Subject: Bairds Farm Shop, Crookthorn Lane, Climping, Littlehampton, West Sussex, BN17 5SN - CM/43/21/DOC

Planning Application reference: CM/43/21/DOC

Proposal: Approval of details reserved by condition imposed under CM/16/21/PL relating to conditions 6-details of proposed grease trap/separator, 7-extraction details & 8-boundary treatments to southern & western boundary.

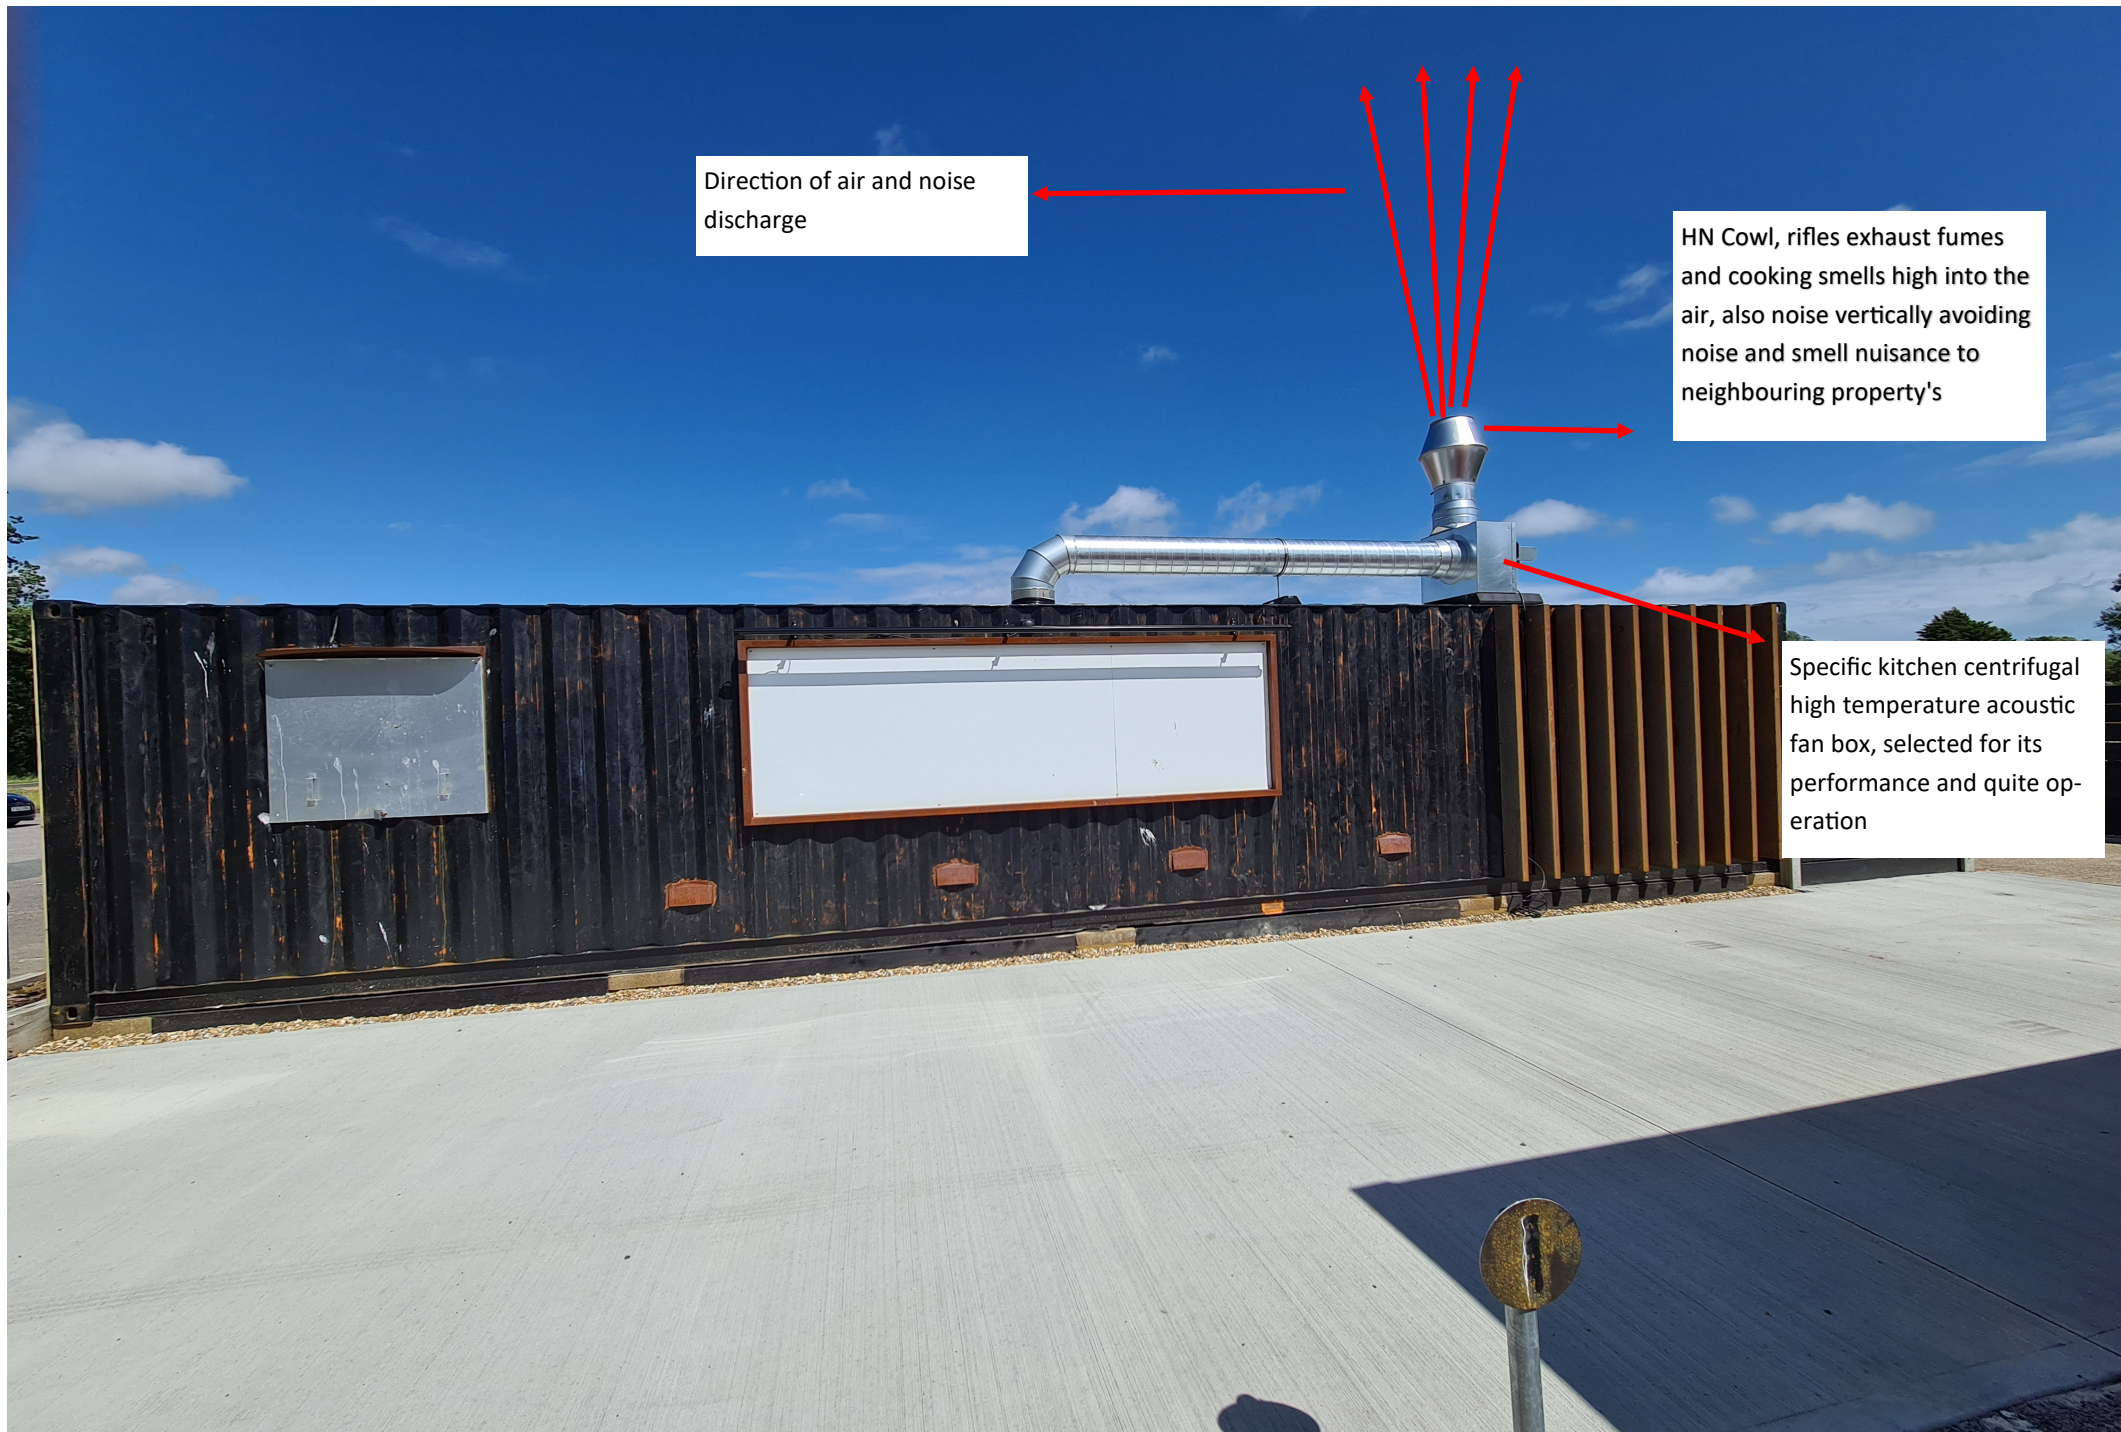
Having reviewed the document entitled 'Ventilation / extraction statement ' [produced by Shear Architectural Design] I note the applicant proposes to use a grease filter, followed by carbon activated pre-

filters and fine filters fitted between the grease filter and fan. The Emaq guidance advises that carbon adsorption filters with a residence time of 0.1 – 0.2 seconds would be required for medium level odour control. It is unclear from the information provided as to the size of kitchen (number of covers per day) and the type of food that will be cooked on site.

Subsequently, the information provided does not demonstrate that the system is in accordance with the EMAQ guidance document – ‘Control of Odour and Noise from Commercial Exhaust Systems, 2018’.

I therefore require the applicant to perform the odour control risk assessment included in the EMAQ guidance to demonstrate that adequate odour control has been installed. The applicant shall provide further information to demonstrate the carbon filter residence time advised by the risk assessment shall be provided by the proposed extraction system.
